BIG "O" TIRES

GRADING AND EROSION CONTROL PLANS

PCD PROJECT NO. SF-18-003

SHEET: **C1.1**

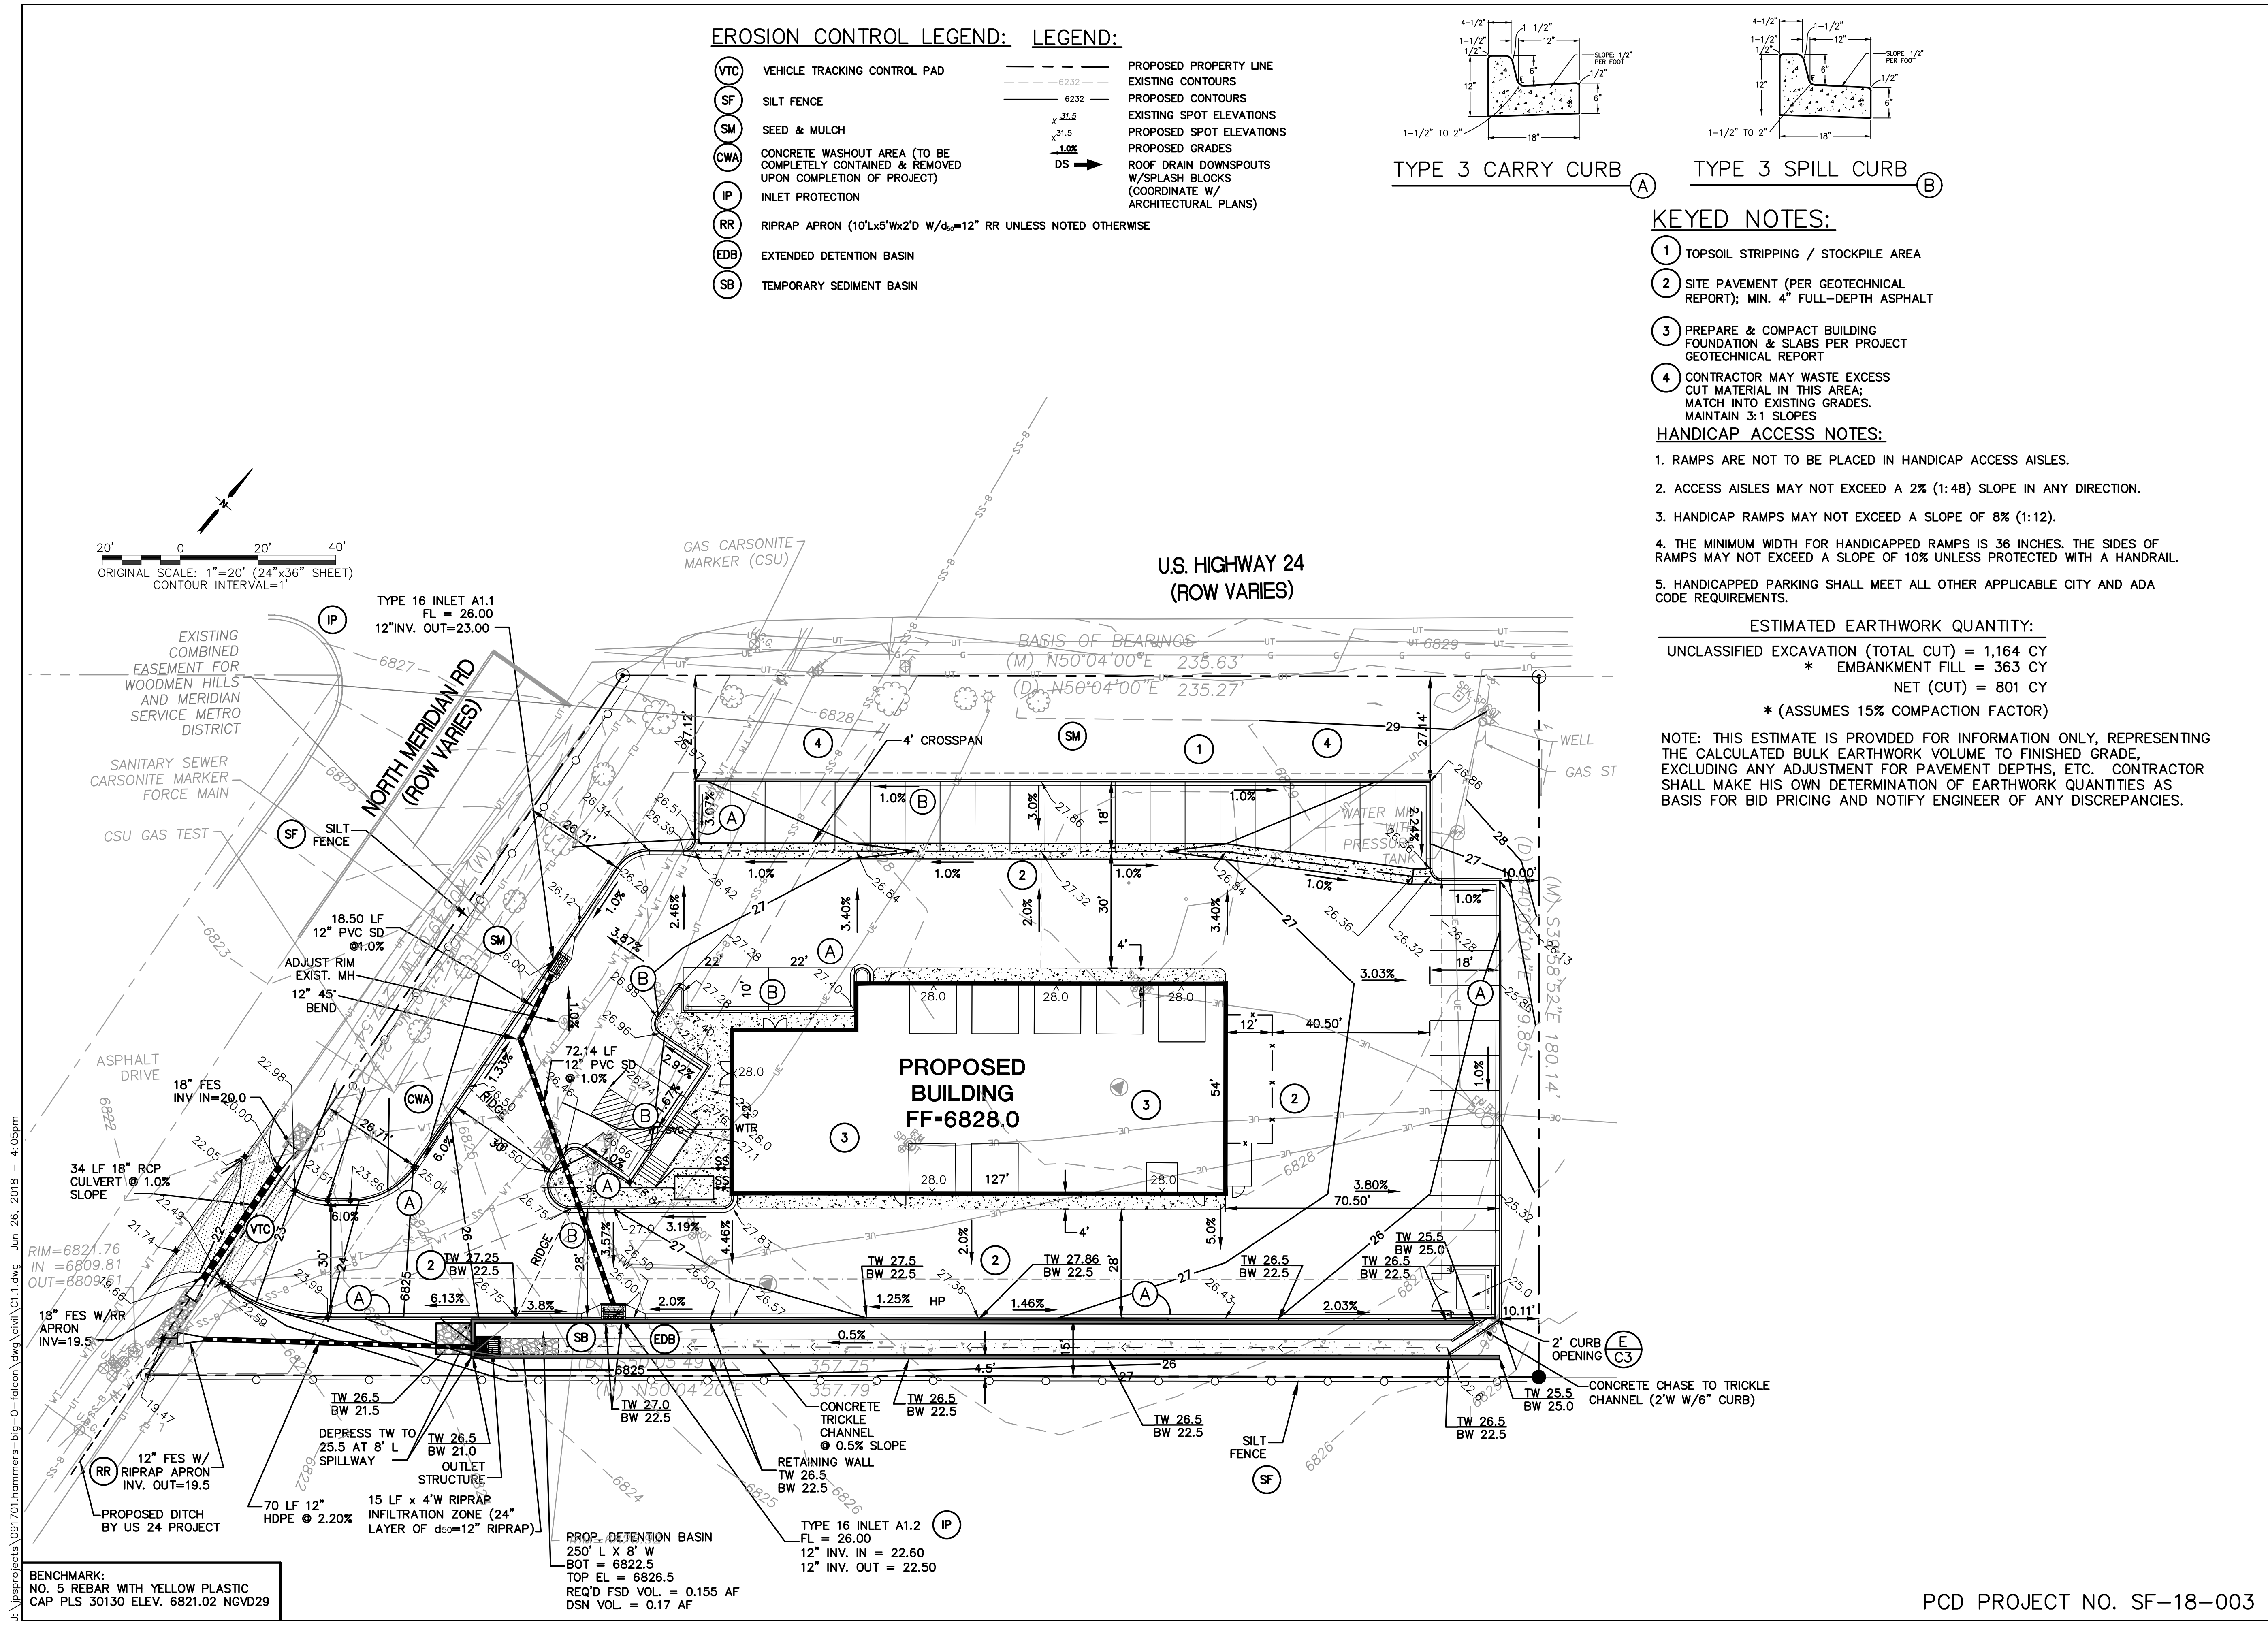
The entrance configuration does not match the autotum exhibit. Update either the plan or the autotum exhibit to match.

The resulting slope exceeds the 2% max for compliance with ADA.

Design volume is less than the required 100yr volume for FSD = 0.18 ac-ft. Revise the pond design accordingly. FYI: This may result in additional comments.
